Requested Revisions for 86 Morning Street Permit Application

Attached please find the updated drawings addressing all of your redlines for the renovation of 86 Morning Street. We now plan to demolish the garage, as it is not salvageable.

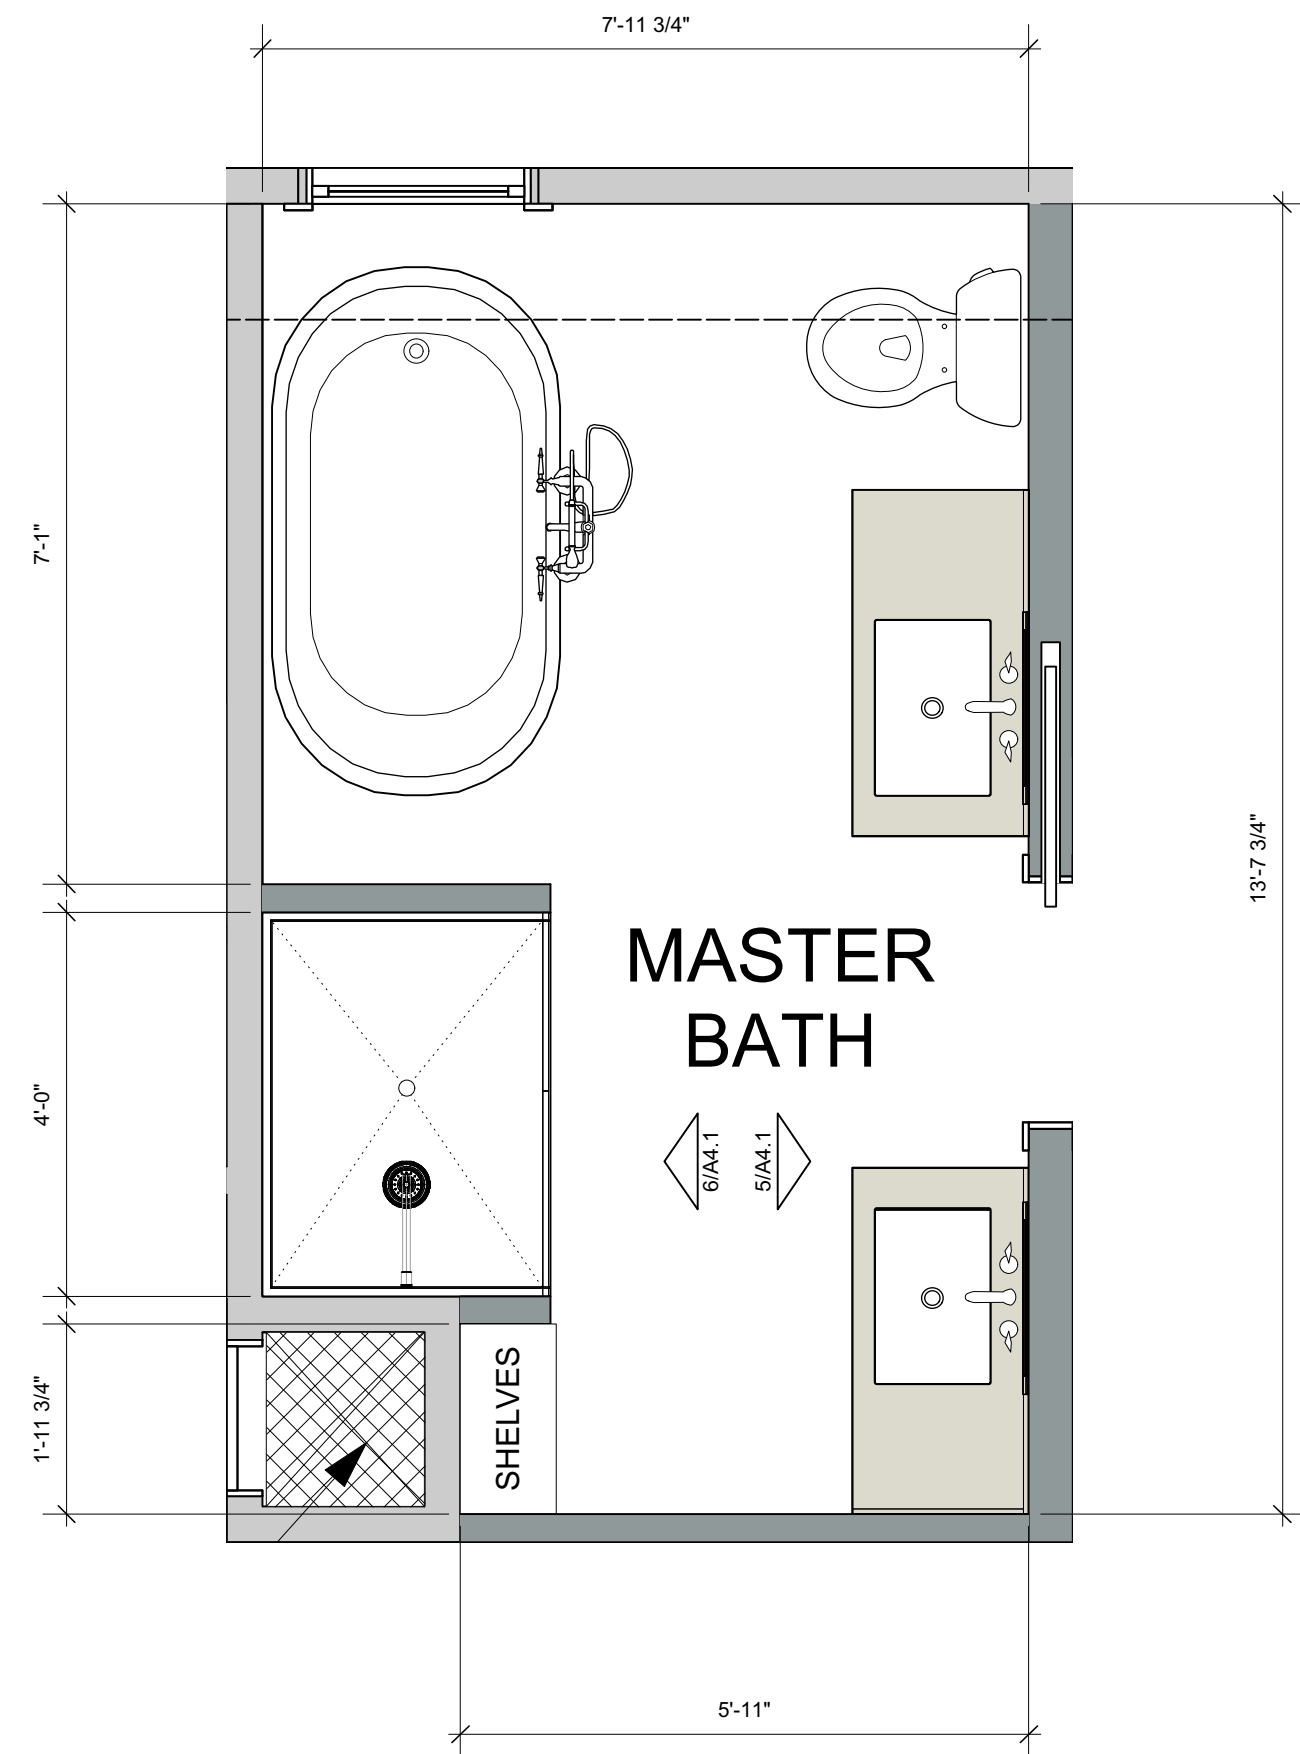
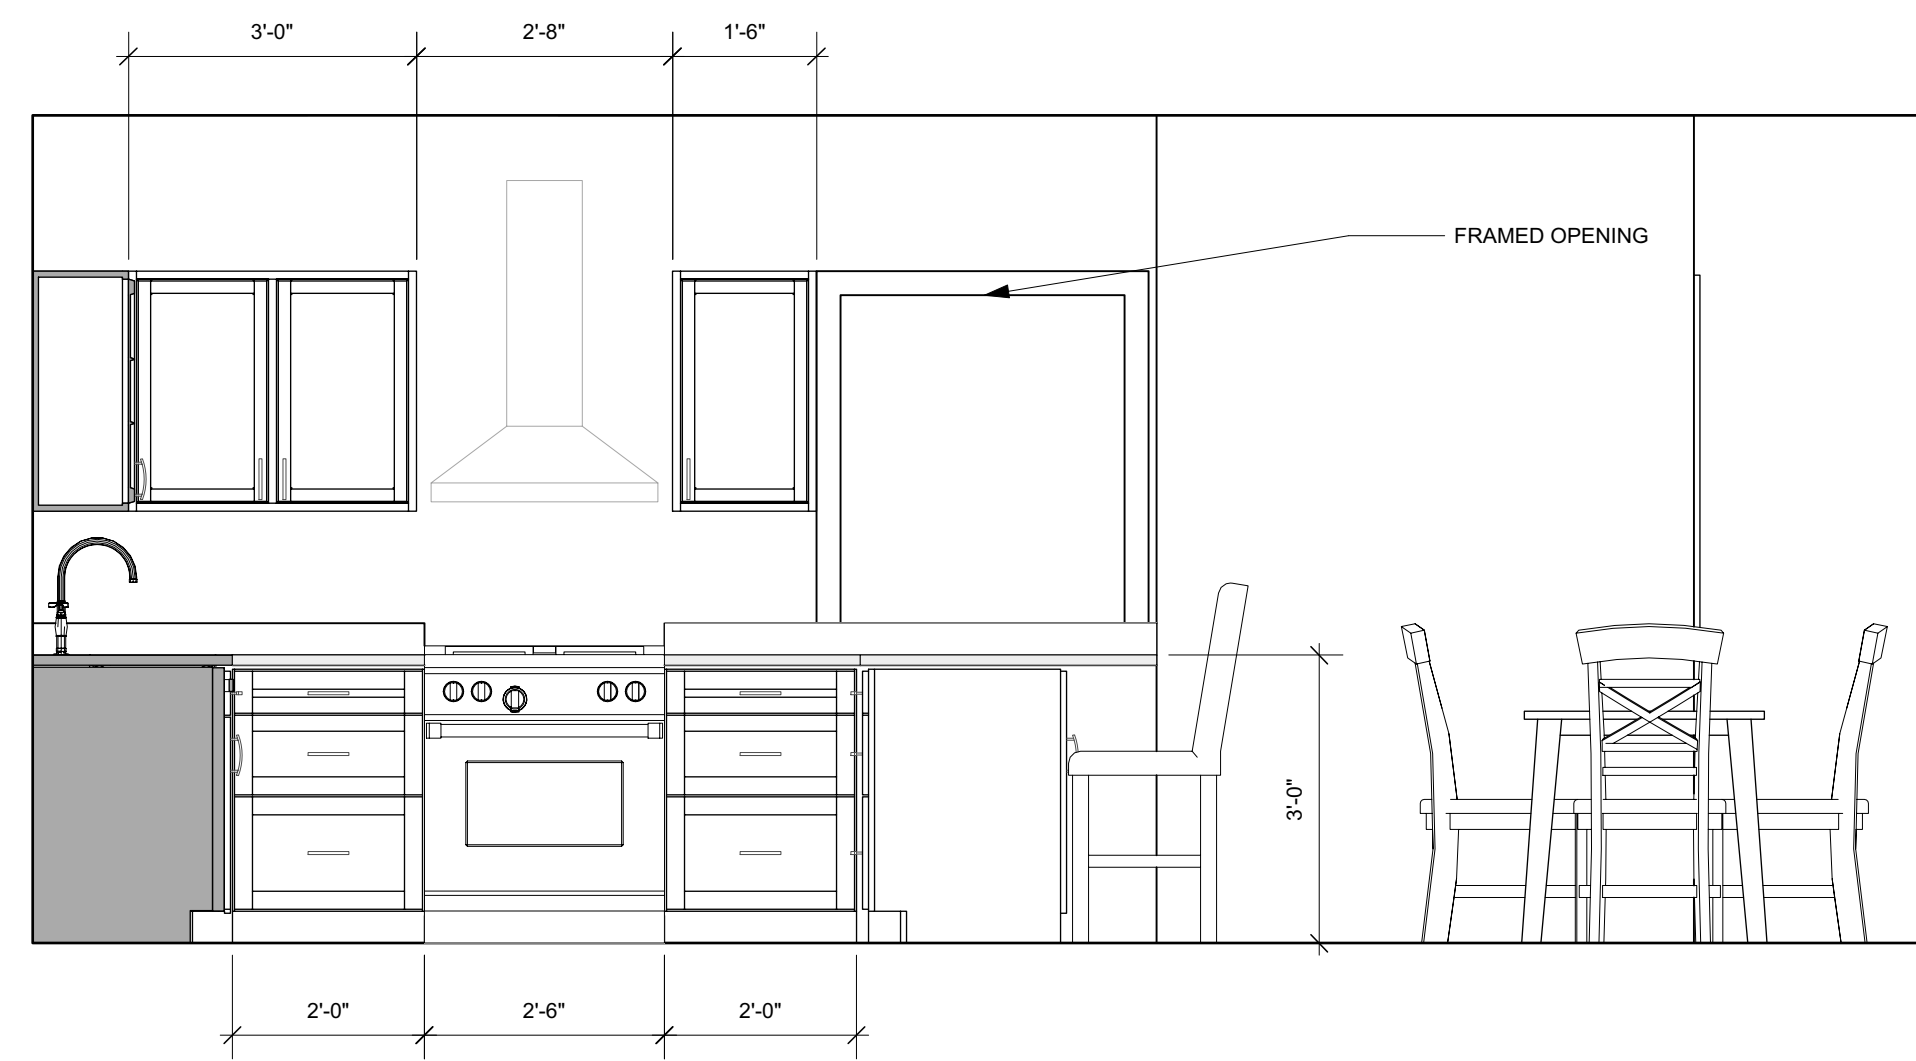
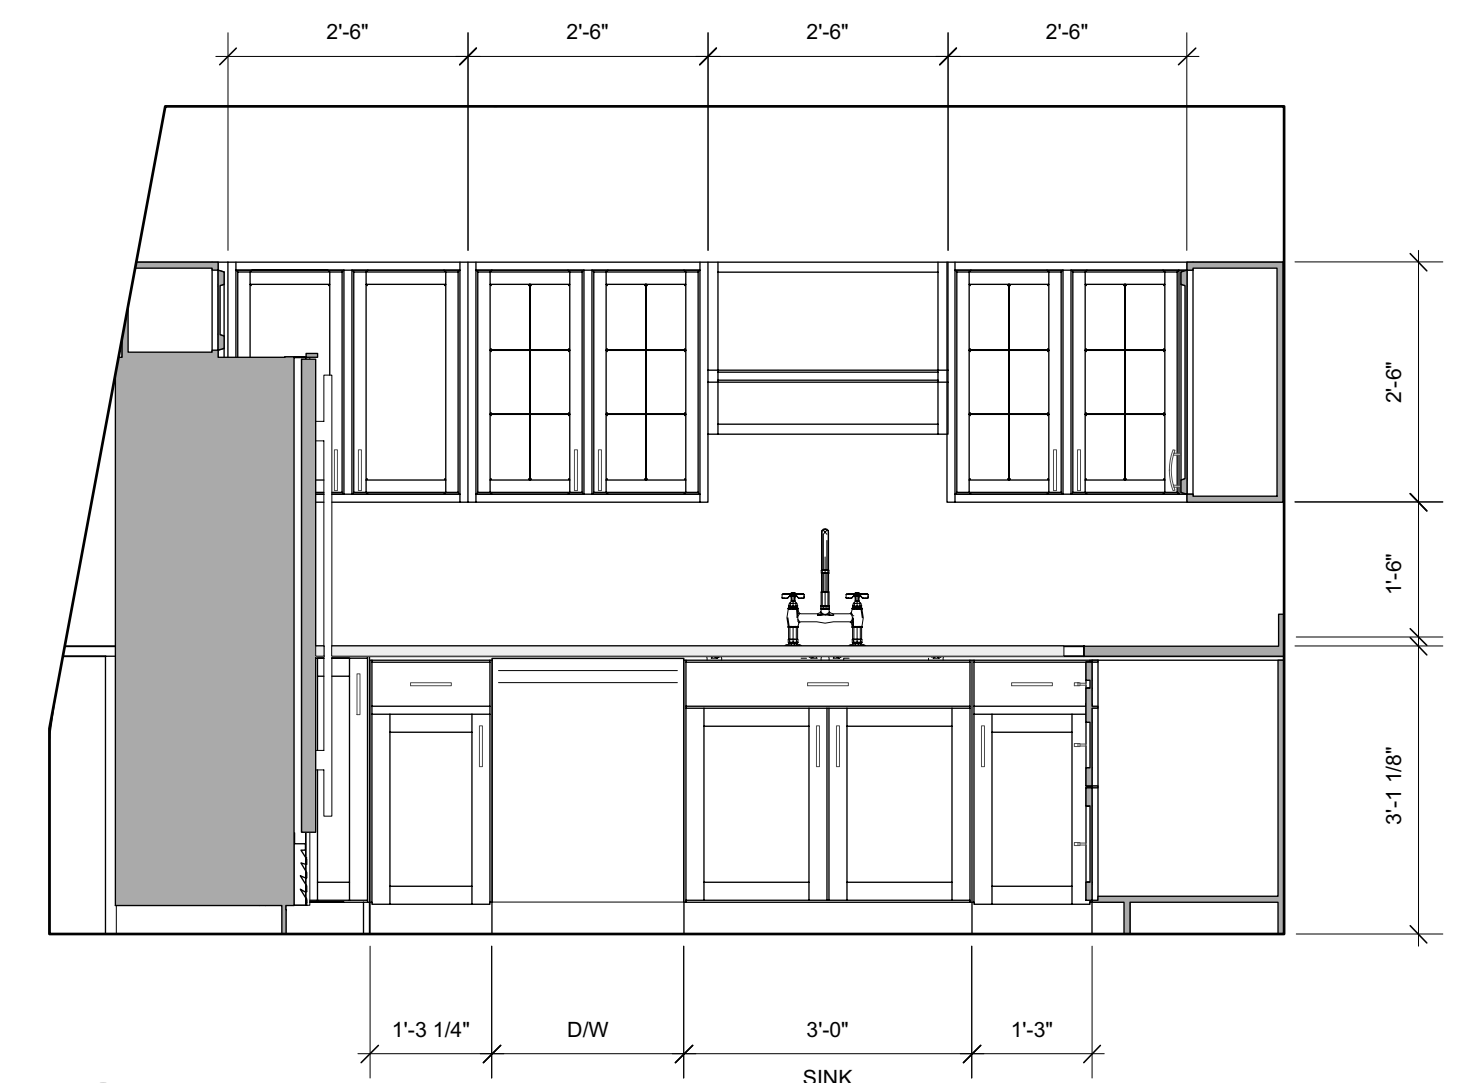
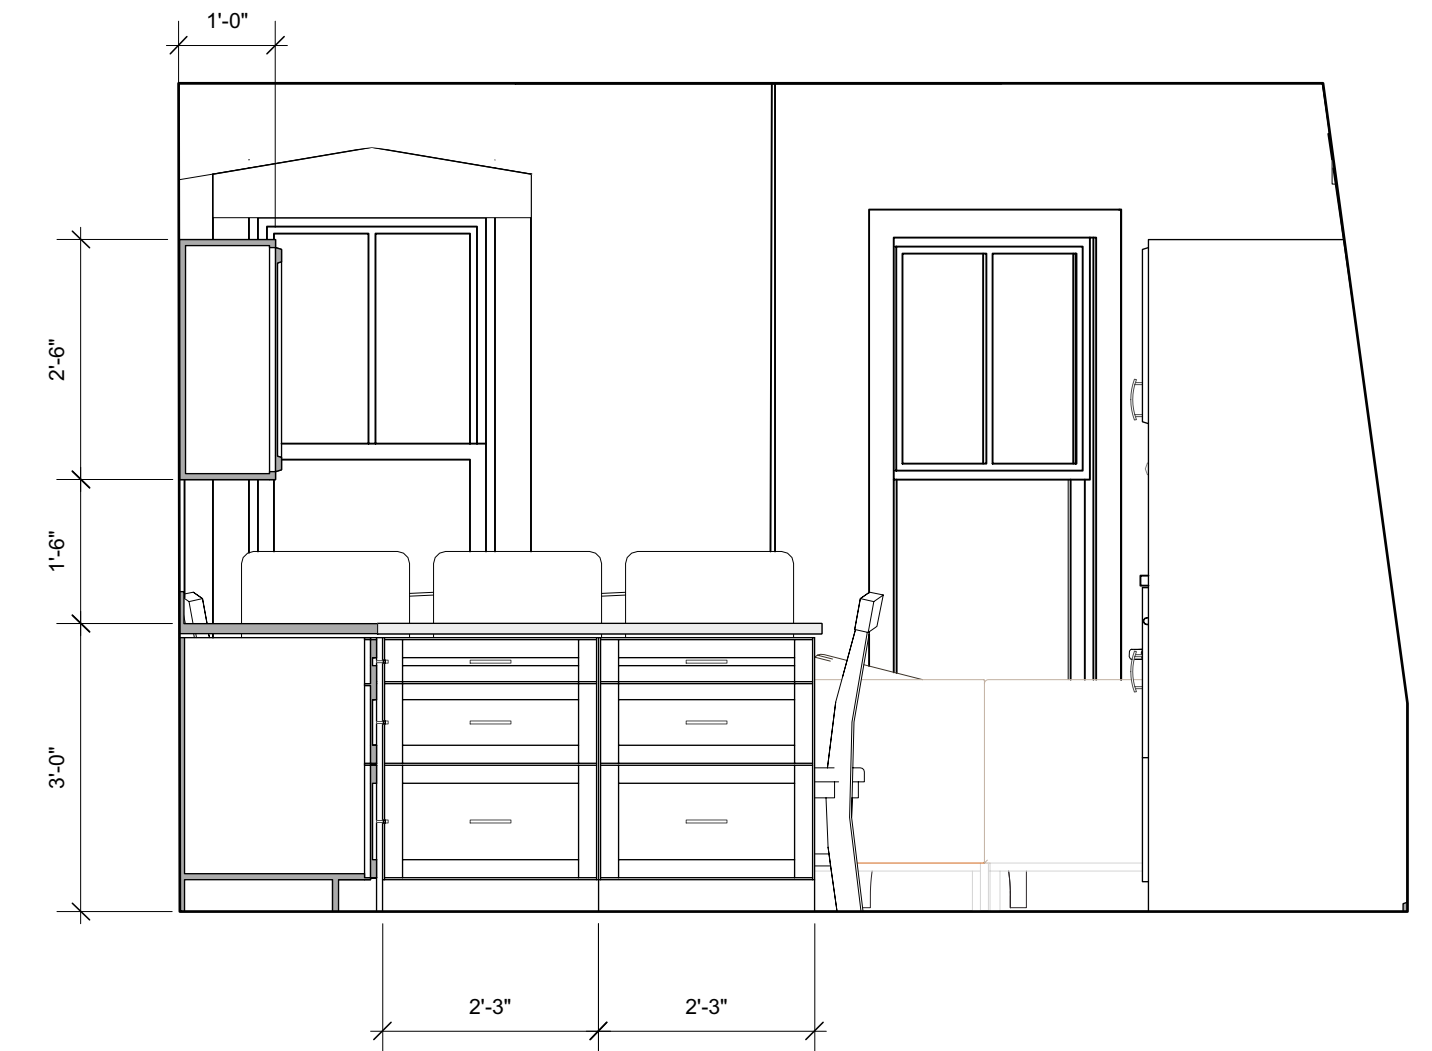
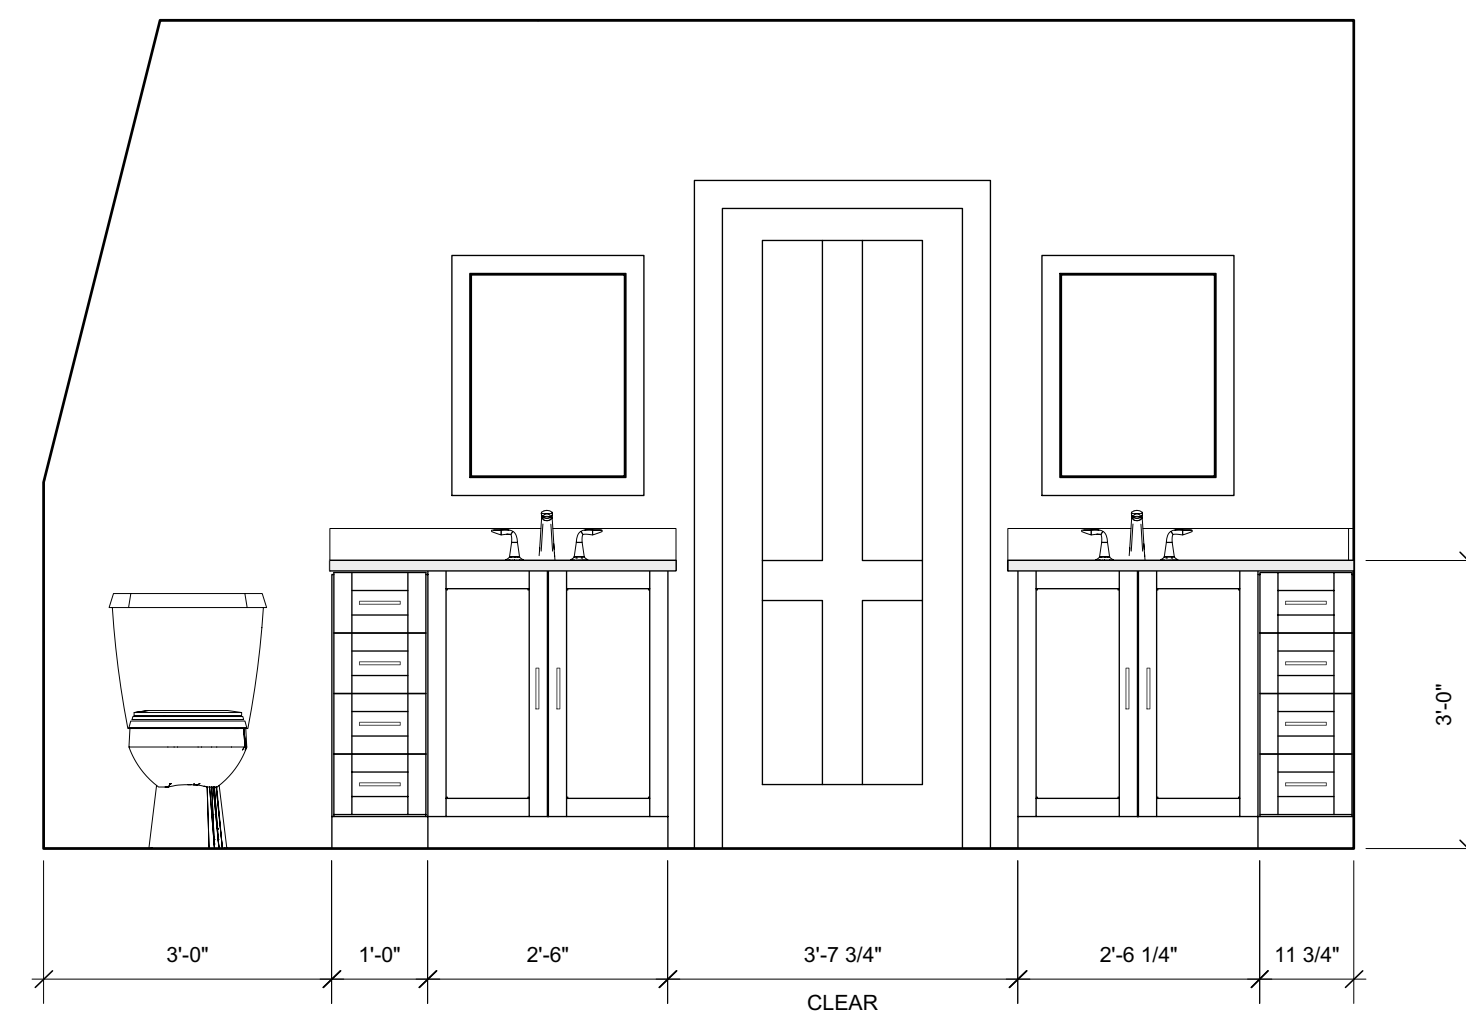
We have separated the Kitchen from the Bathroom interior elevations, so the tempered glass that is required at the bath tub originally shown on A4.1 is now illustrated on sheet A4.3.

- Note referencing tempered glazing at tub as shown on A4.3
-
